STATE OF NORTH CAROLINA
DEPARTMENT OF TRANSPORTATION

Addendum No. 1

RE: Contract ID: C201604
WBS # 33066.3.2
F.A. # BRSTP-1243(4)
Davidson County (B-3446)
Bridge over Norfolk Southern Railroad and
Approaches on SR 1243

August 21, 2007 Letting

REVISIONS						SHEET NO.
NO.	BY:	DATE:	NO.	BY:	DATE:	S-2
1			3			TOTAL SHEETS
2			4			30

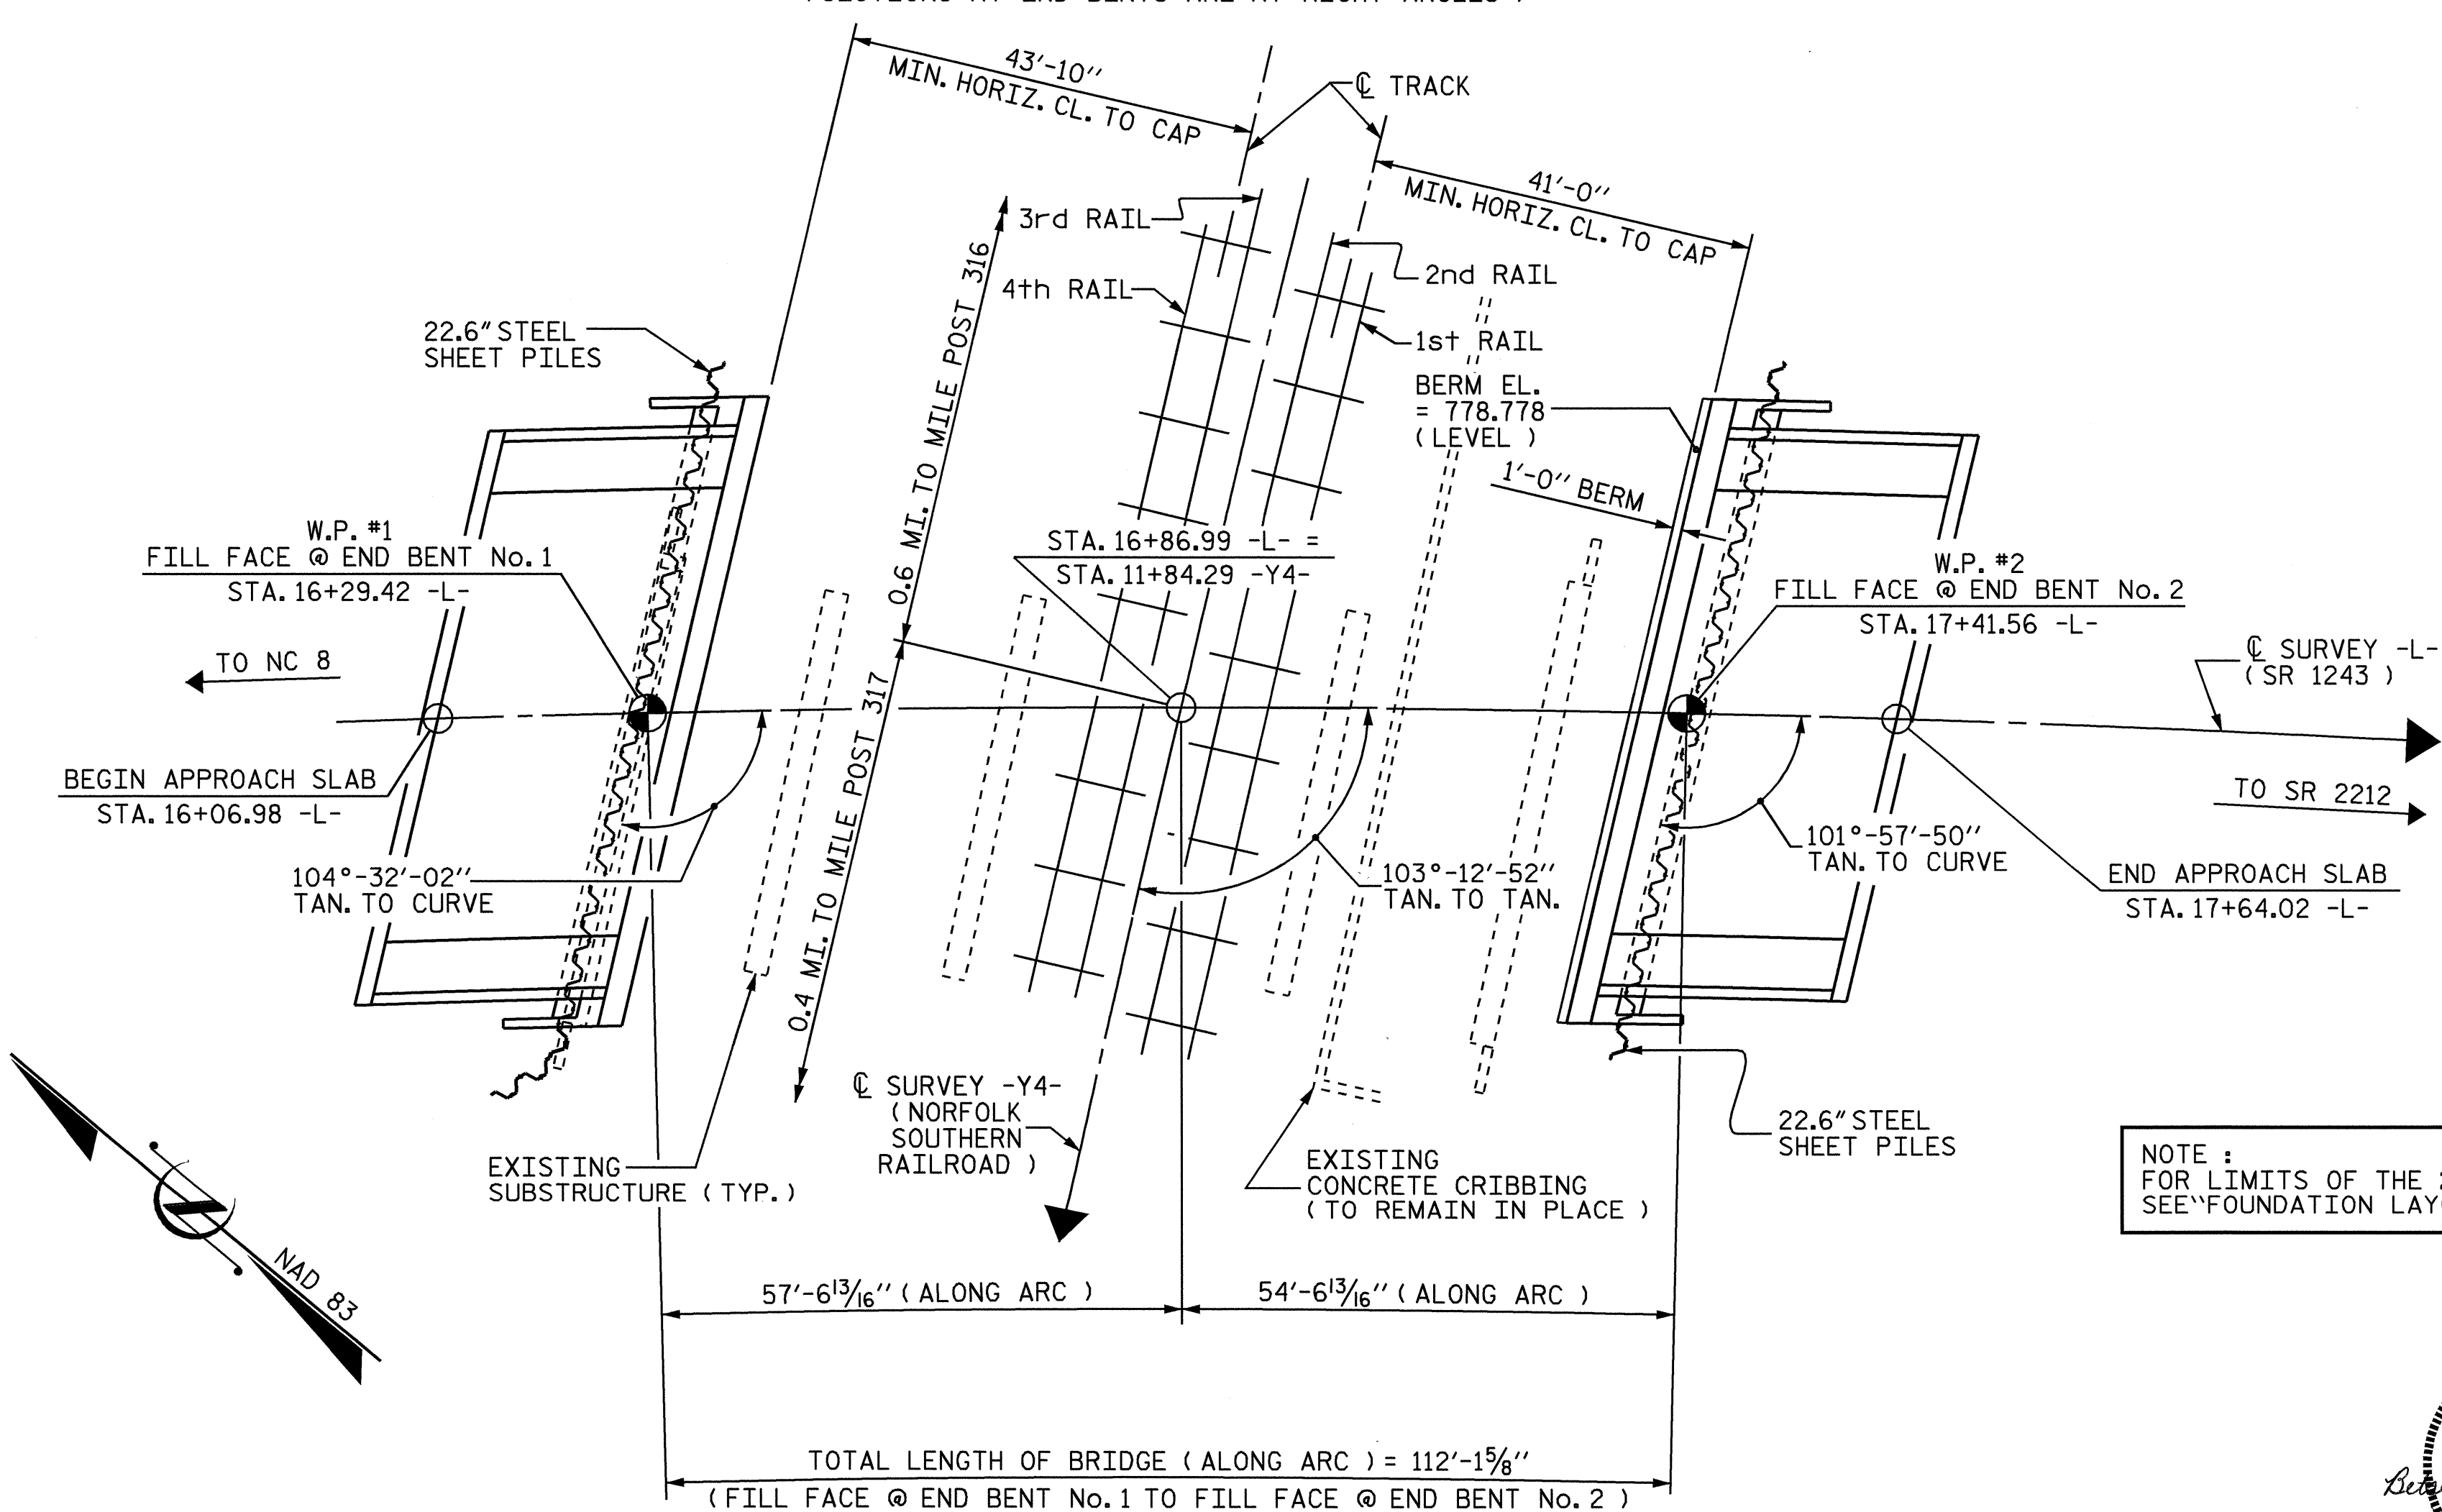
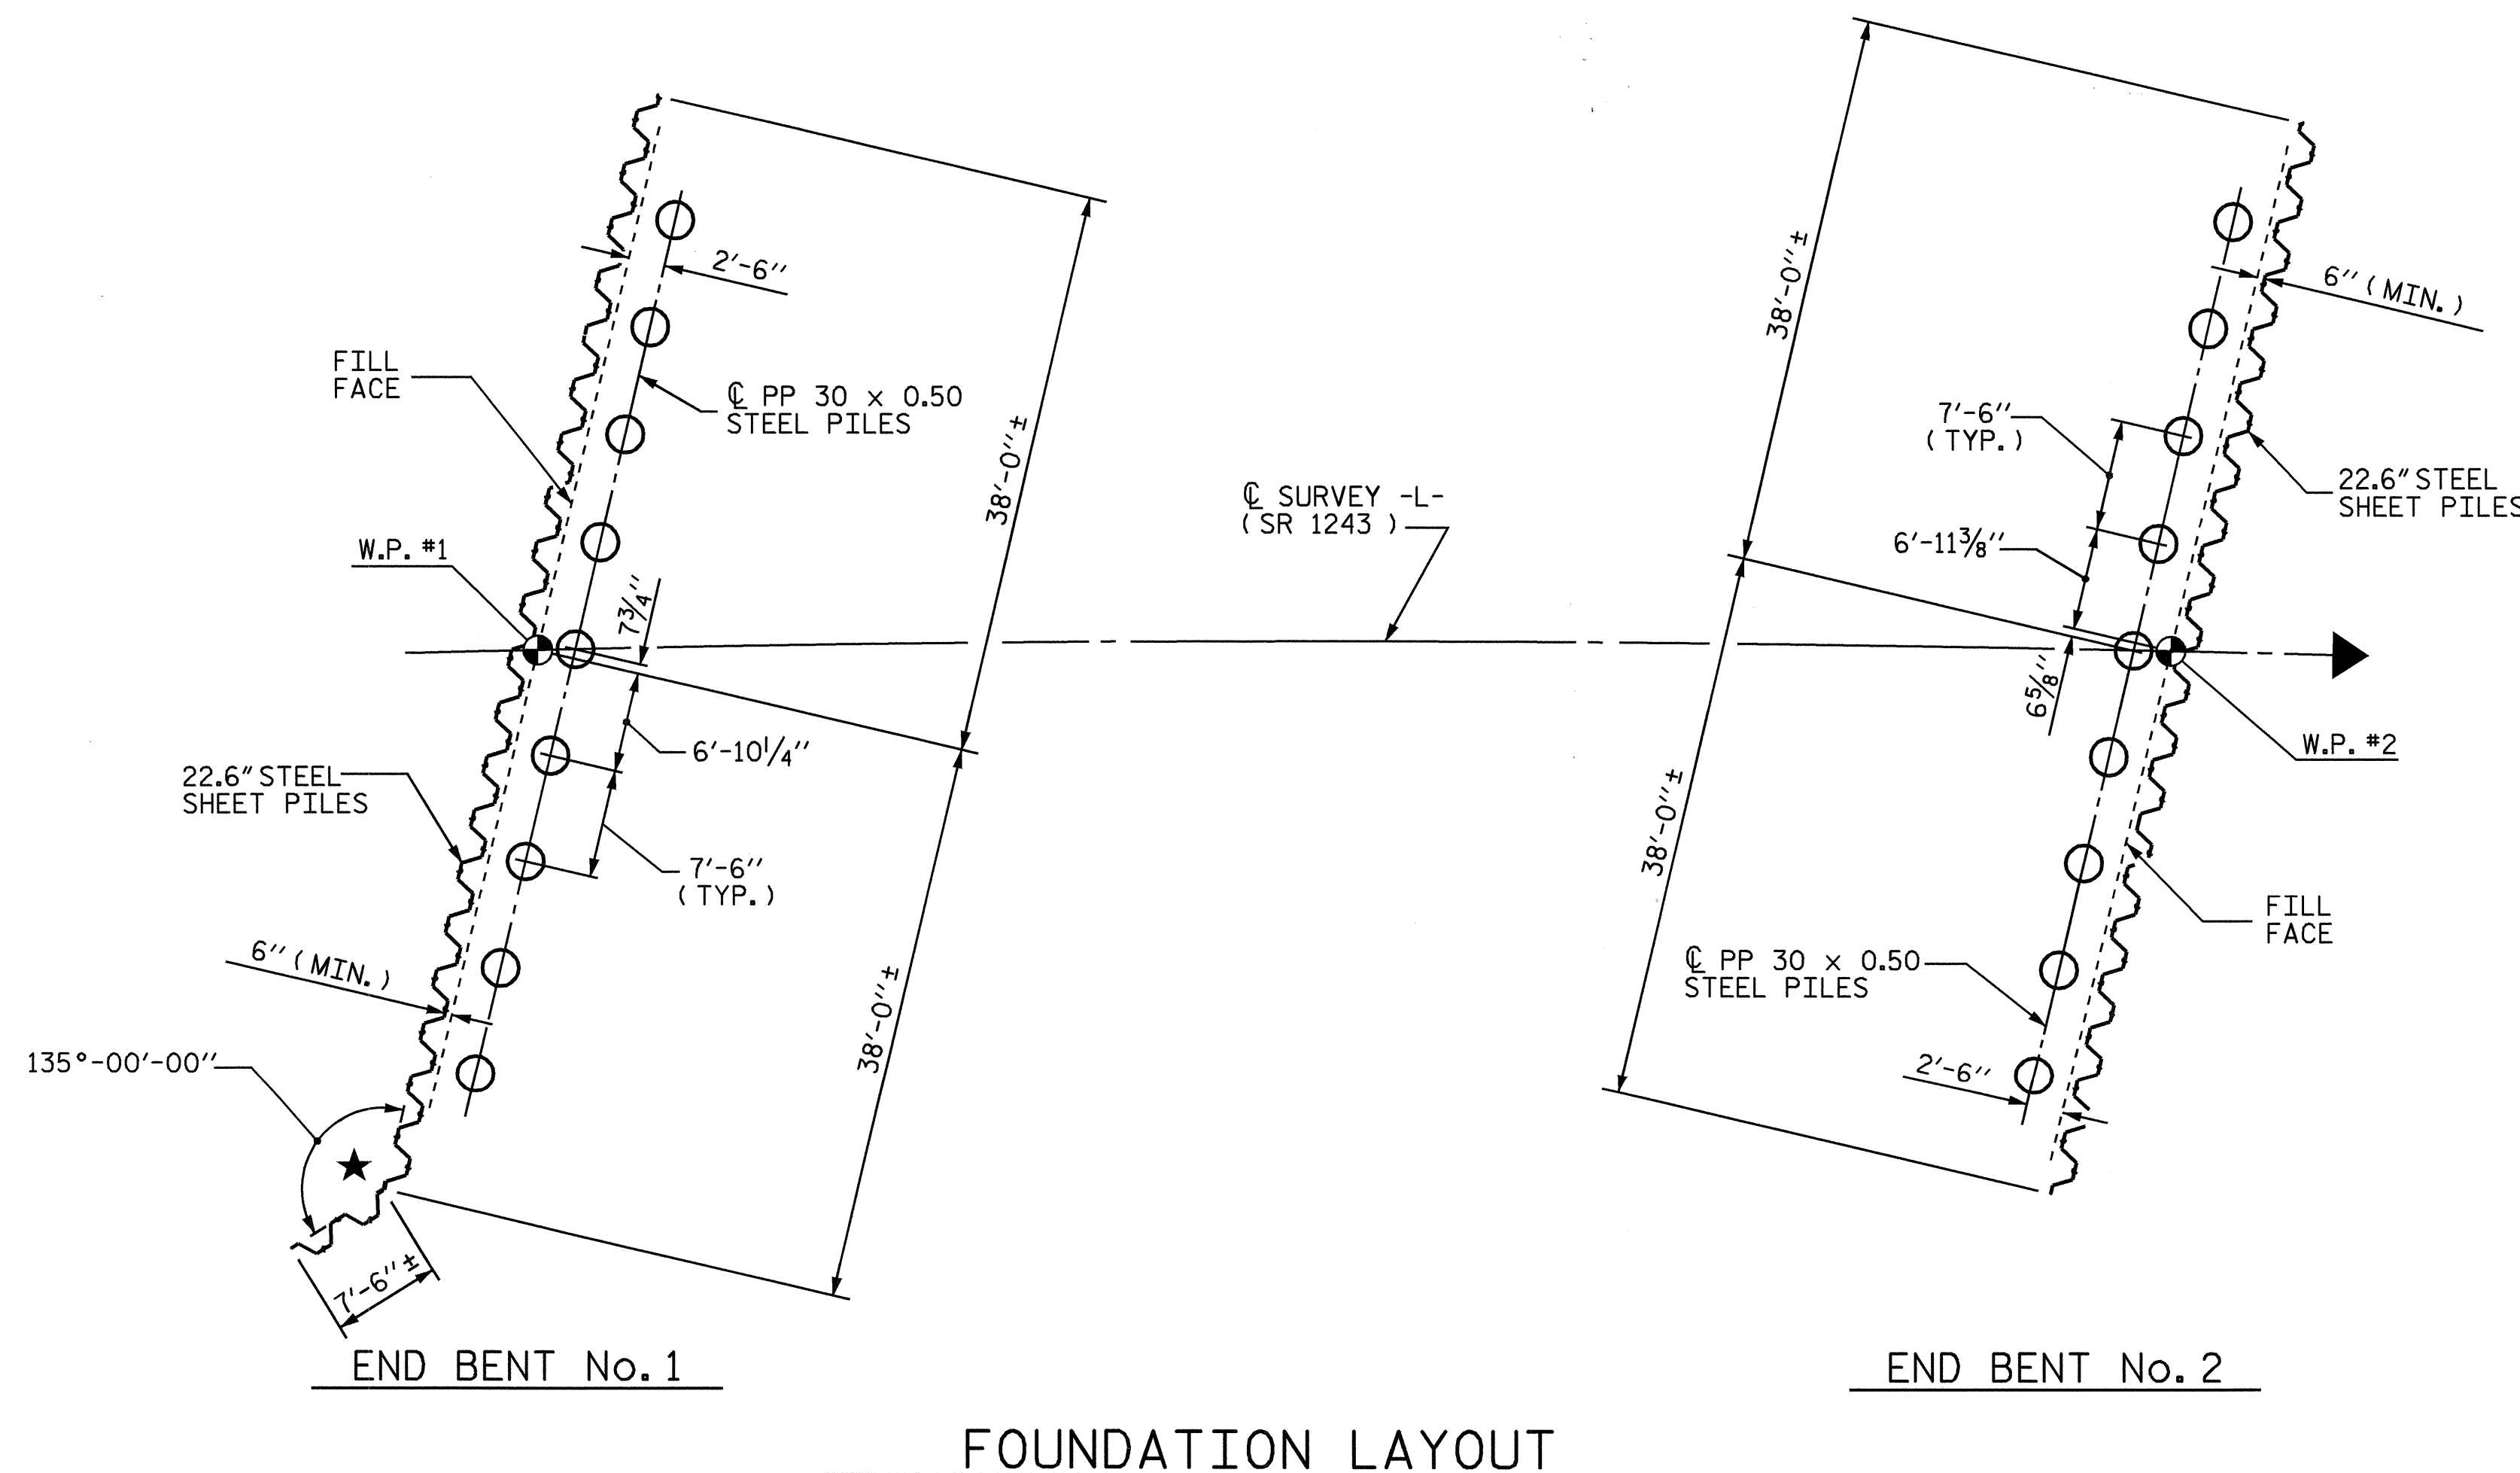
The following sheets in the Structure plans have been revised: Sheet Nos. S-2, S-3, S-7, S-8, S-9 and S-10.

Various notes and dimensions have been revised on these sheets as a result of changing from "High Performance Steel (HPS 70W)" to "AASHTO M270 Grade 50W".

Please void Sheet Nos. S-2, S-3, S-7, S-8, S-9 and S-10 in your plans and staple the revised Sheet Nos. S-2, S-3, S-7, S-8, S-9 and S-10 thereto.
